DEVELOPMENT HEARING OFFICER
SUPPLEMENTAL SUBMITTAL

PROJECT NO. PR-2022-007680
Application No. SD-2023-00100

Re: Preliminary / Final Plat Review for Proposed Lot 1-A, Block 5 of Ives Addition, being comprised of Lots 1 thru 4, Block 5 of Ives Addition (601 Aspen Ave NW)

A final plat review for this replat was held on May 24, 2023 under PR-2023-008660 / SD-2023-00100, and the comments from that hearing are addressed below:

**Plat for  
Lot 1-A, Block 5  
Ives Addition  
Being Comprised of  
Lots 1 Thru 4, Block 5  
Ives Addition  
City of Albuquerque, Bernalillo County, New Mexico  
March 2023**

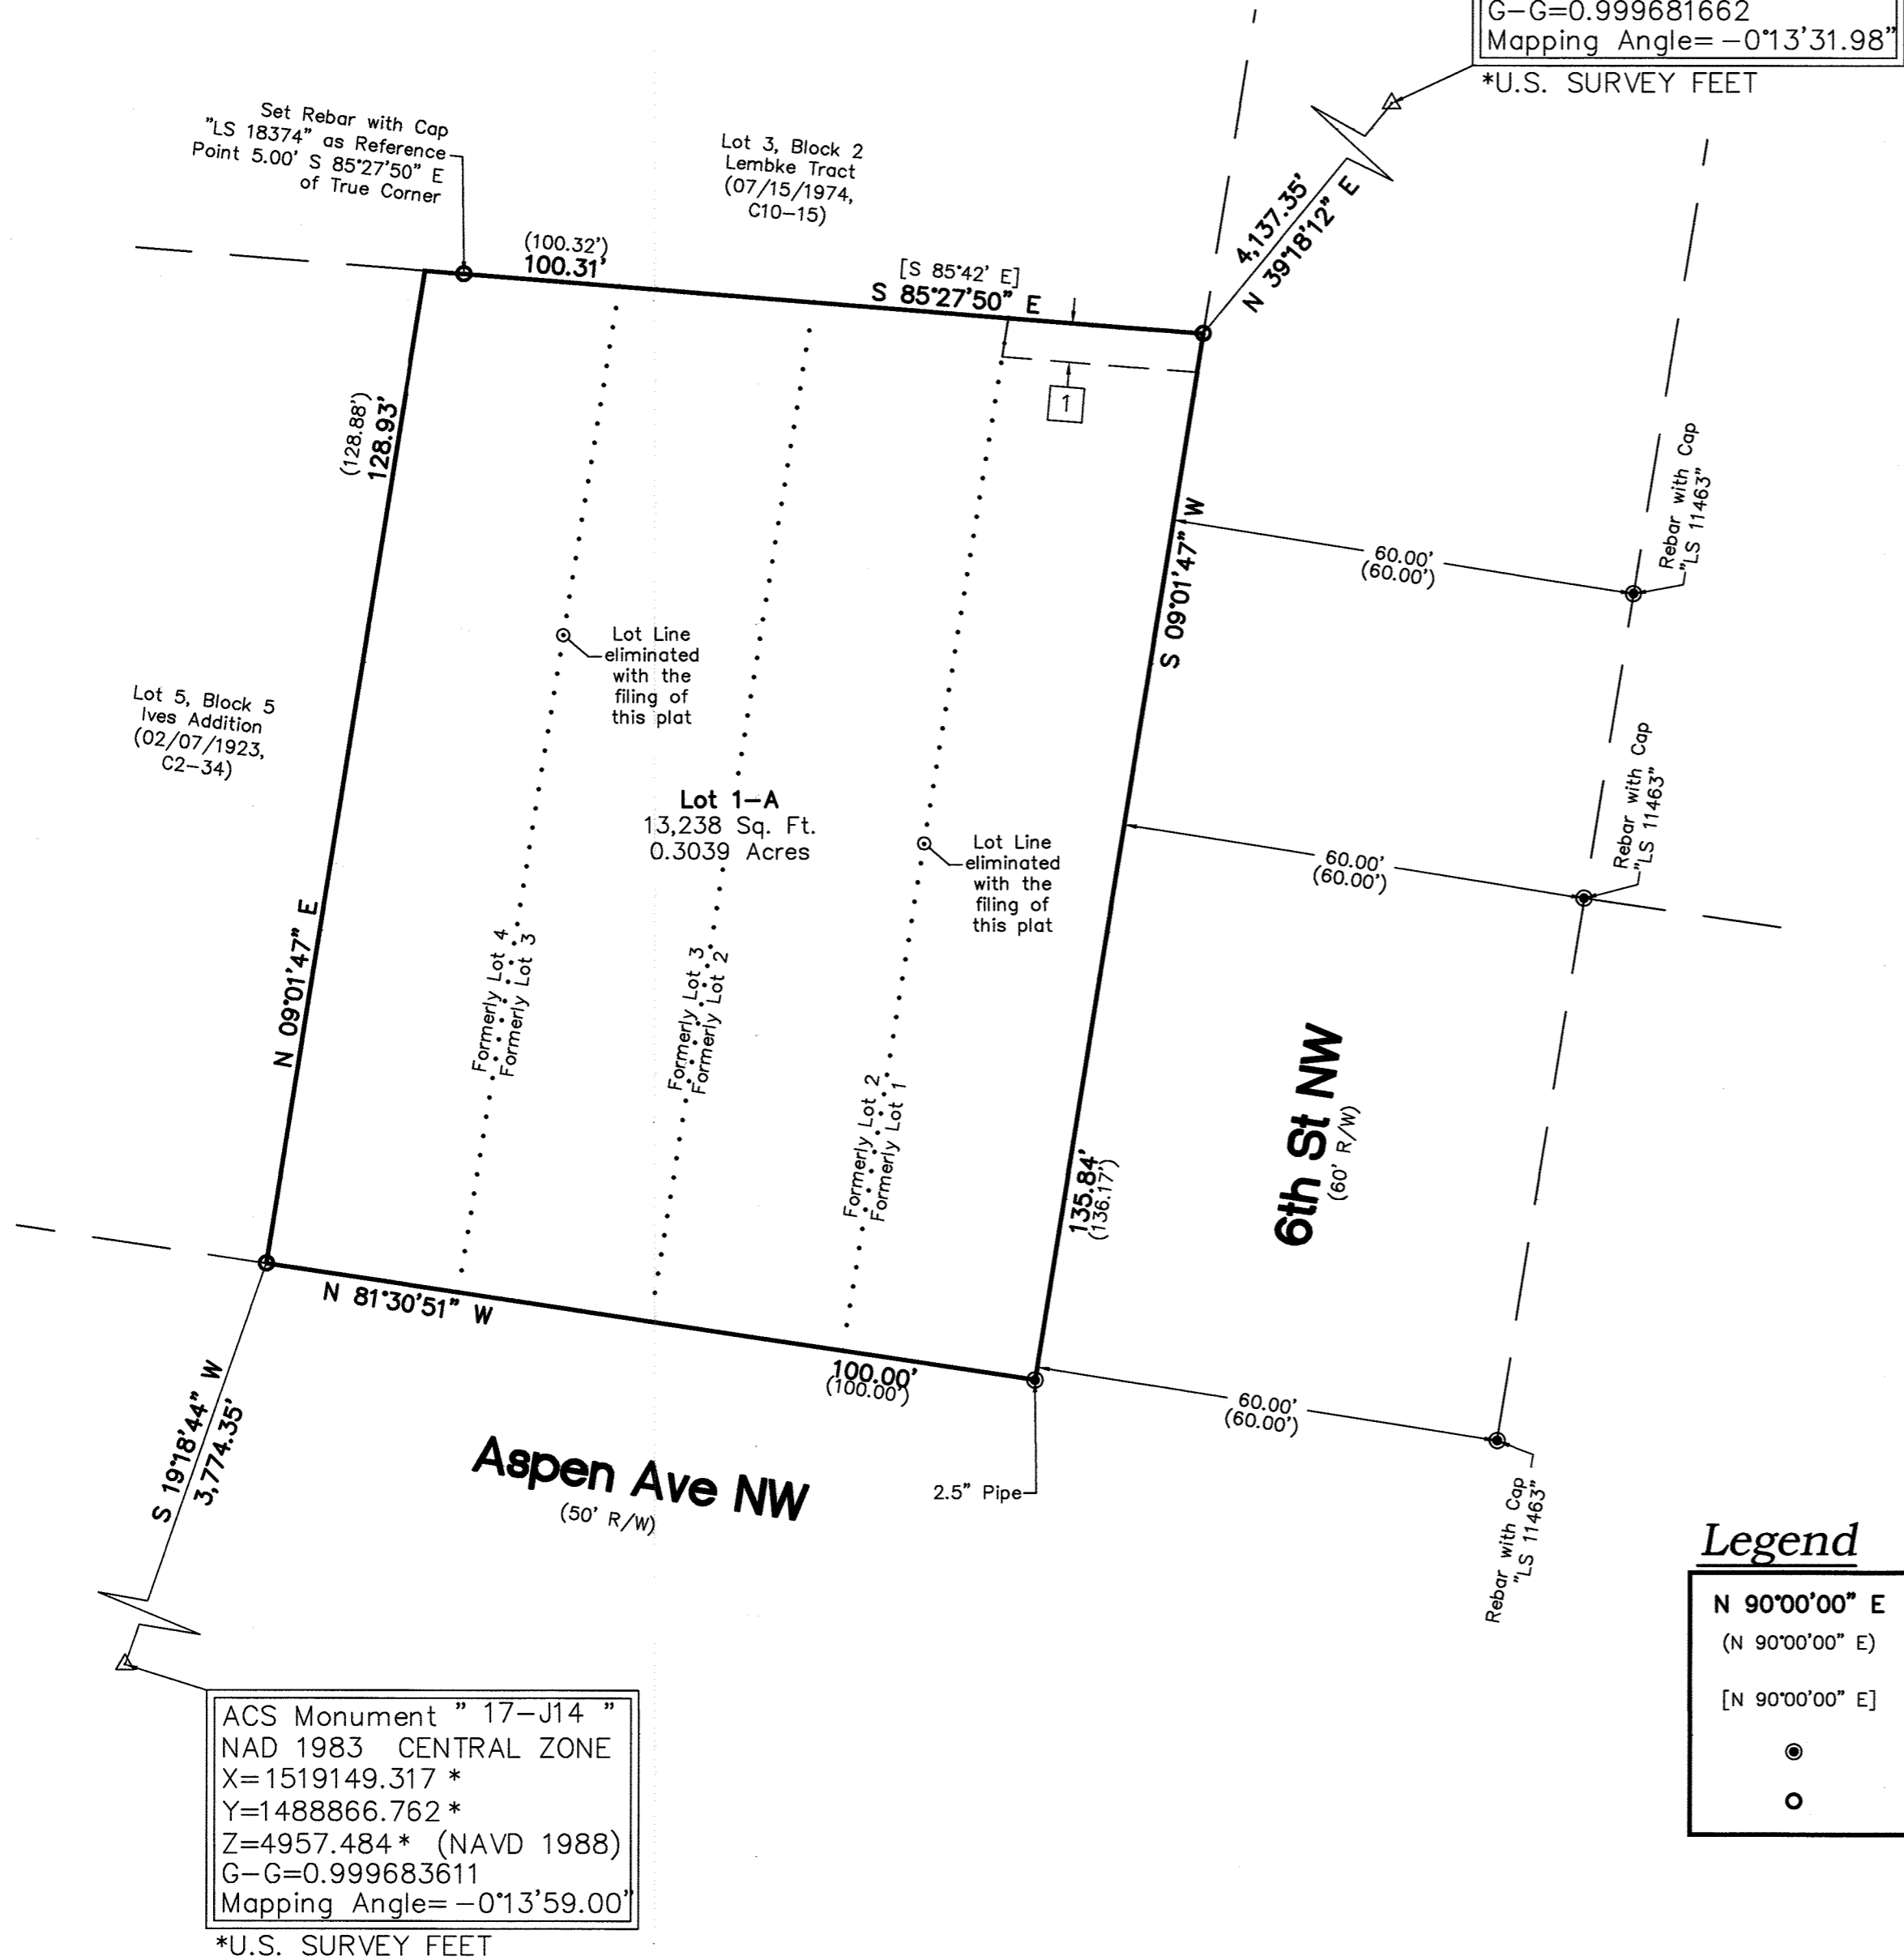
1. 6th Street is a minor arterial and requires 6' sidewalks with a 5-6' landscape buffer. Aspen is a local street and requires 5' sidewalk with a 4-6' landscape buffer. From the plat it appears there is adequate ROW to fit this in.

2. A Minor Arterial is required to have a minimum 82' ROW, while your plan shows only 60'. Please provide ROW dedication or request a determination with a justification letter explaining why the ROW cannot be provided

Noted, we request a determination from sidewalk width along 6th Street NW, see justification letter following this one. Our client intends to widen the sidewalk along Aspen Ave NW, as shown on the attached infrastructure list.

Noted, we request a determination from right-of-way width for 6th Street NW right-of-way, see justification letter following this one.
